Date: 26-Oct-2021
Our Ref: 2021/93851

**Application for a non-material amendment following a grant of planning permission,
Town and Country Planning Act 1990**

**Non material amendment to previous permission 2021/92105 for erection of two
storey extension to rear
68, Newsome Road, Newsome, Huddersfield, HD4 6NQ
Application Number: 2021/93851**

Client		Mr & Mrs Smith	
Job		68 Newsome Road Newsome	
Title		Proposed Rear Elevation	
Drawn By	RK	Date	Jan 2021
Eng. Check		Scale	1:50
Tech. Check			
Drawing No.		Rev.	
2021 / 272 / 02

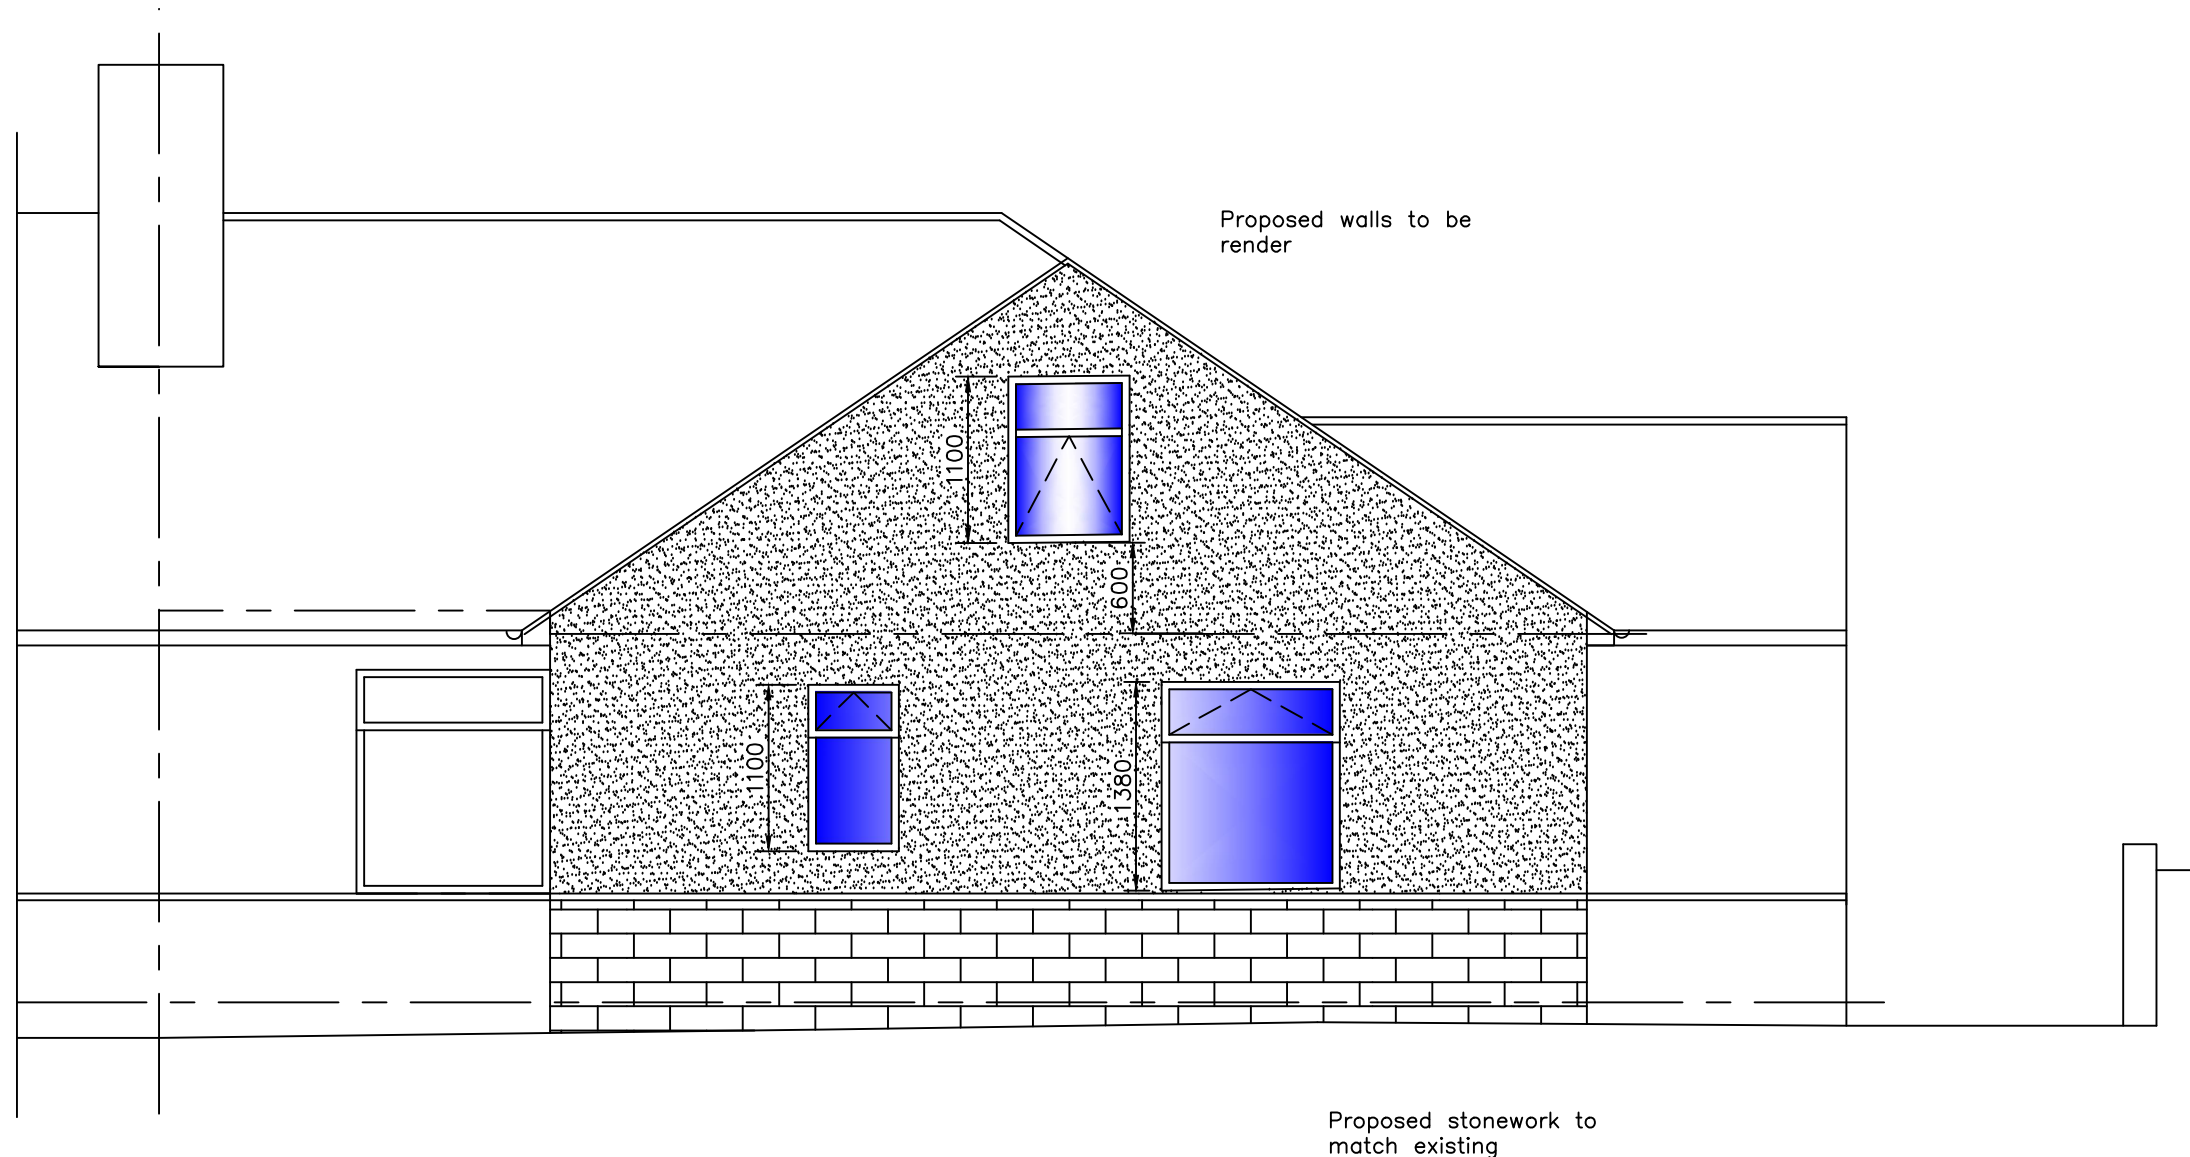
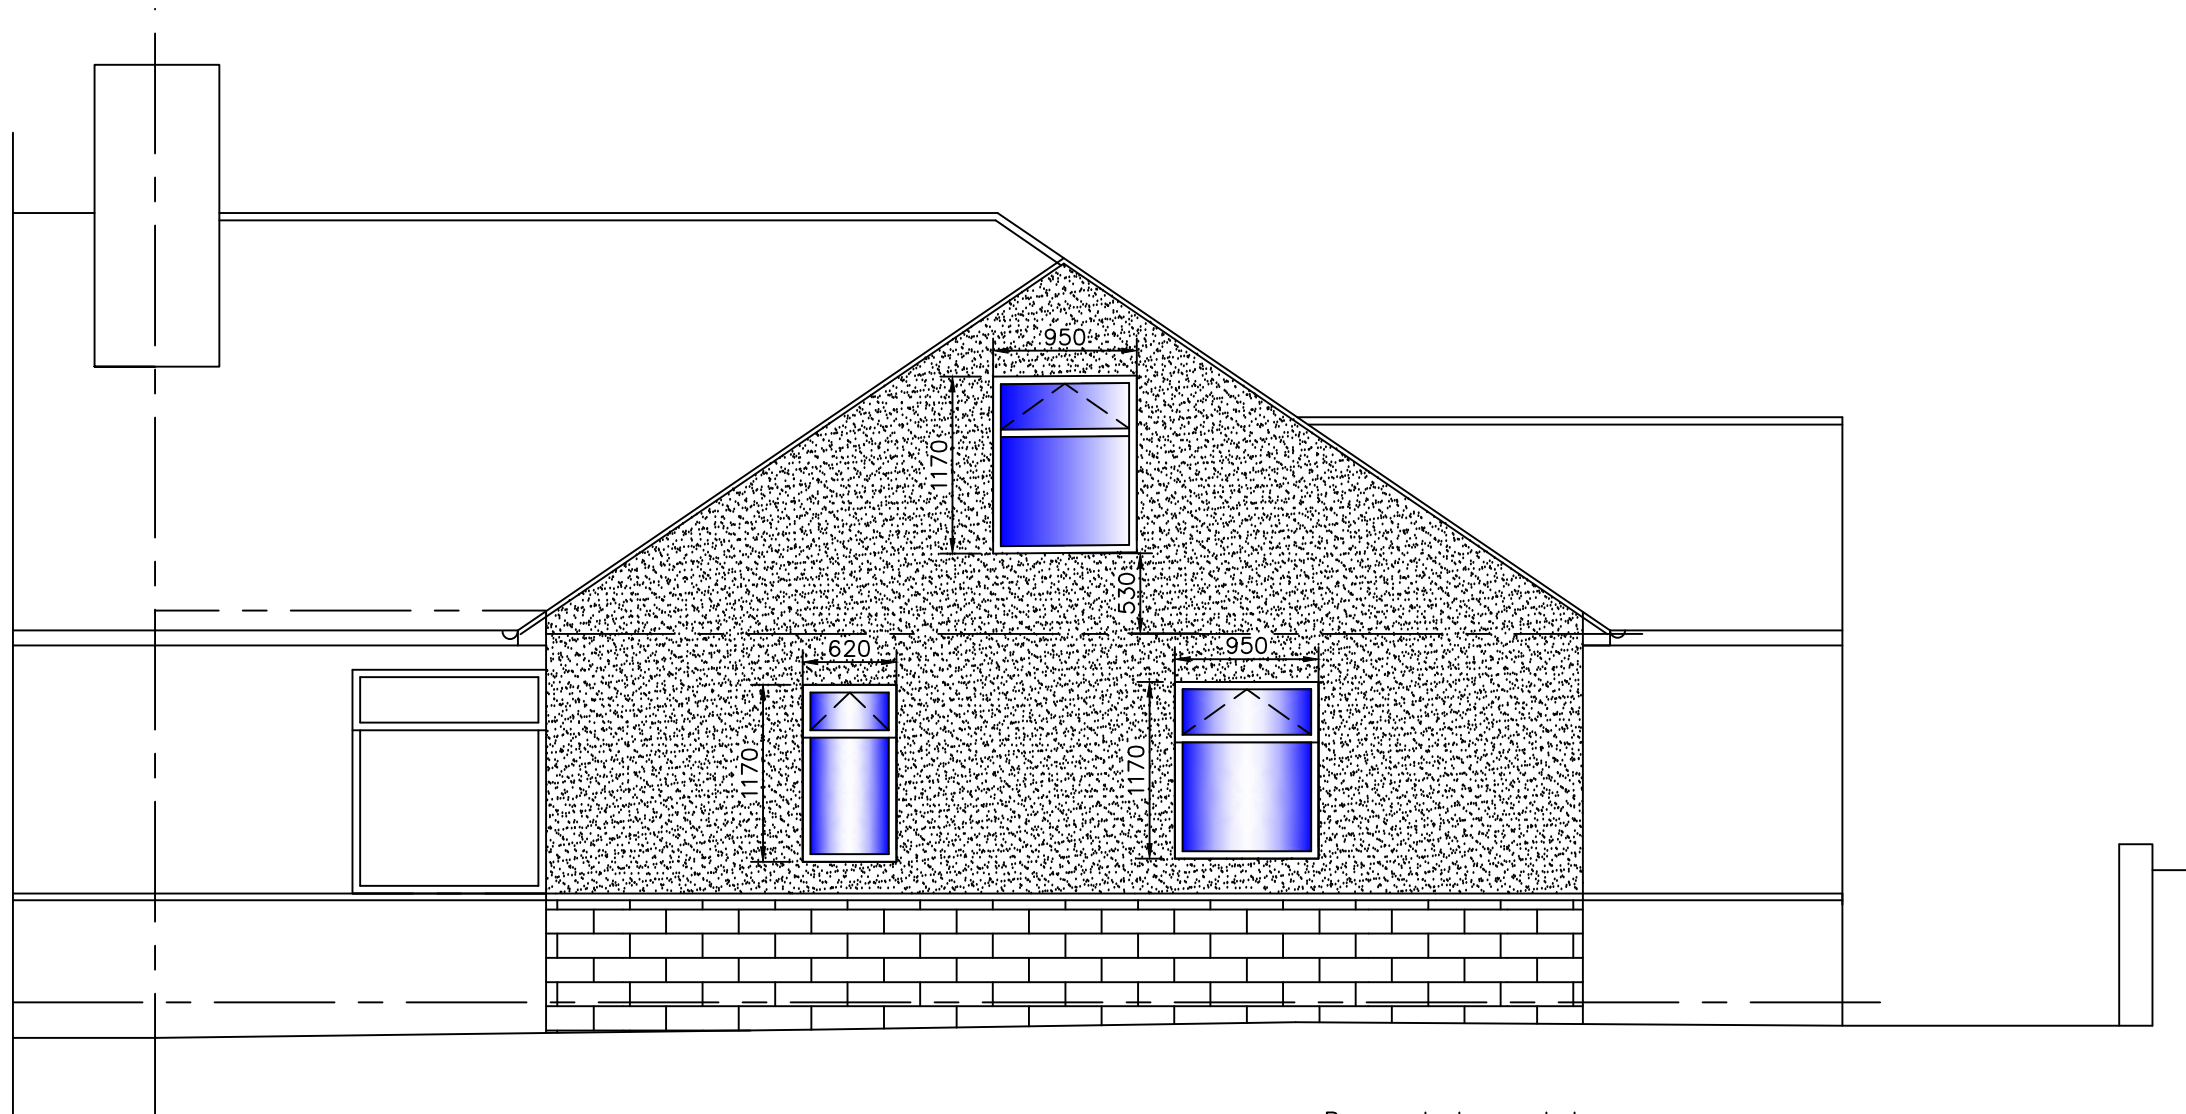
Thank you for your application dated 04-Oct-2021 for a non-material amendment to the above scheme. The amendment sought is to alter the heights of the proposed 3 no. openings to 1170mm as shown on drawing number 2021/272/02 received by the Local Planning Authority on 18th October 2021.

I confirm that the alterations are acceptable and may be considered as a non-material amendment to the approved drawings. It should be noted that this letter relates only to the non-material amendment sought and it is not a re-issue of the original planning permission. The two documents should be read together and as such, all conditions imposed on the original granting of planning permission apply to the proposal as now amended. A copy of this letter and the amended plans will be retained on the public record of approved documents.
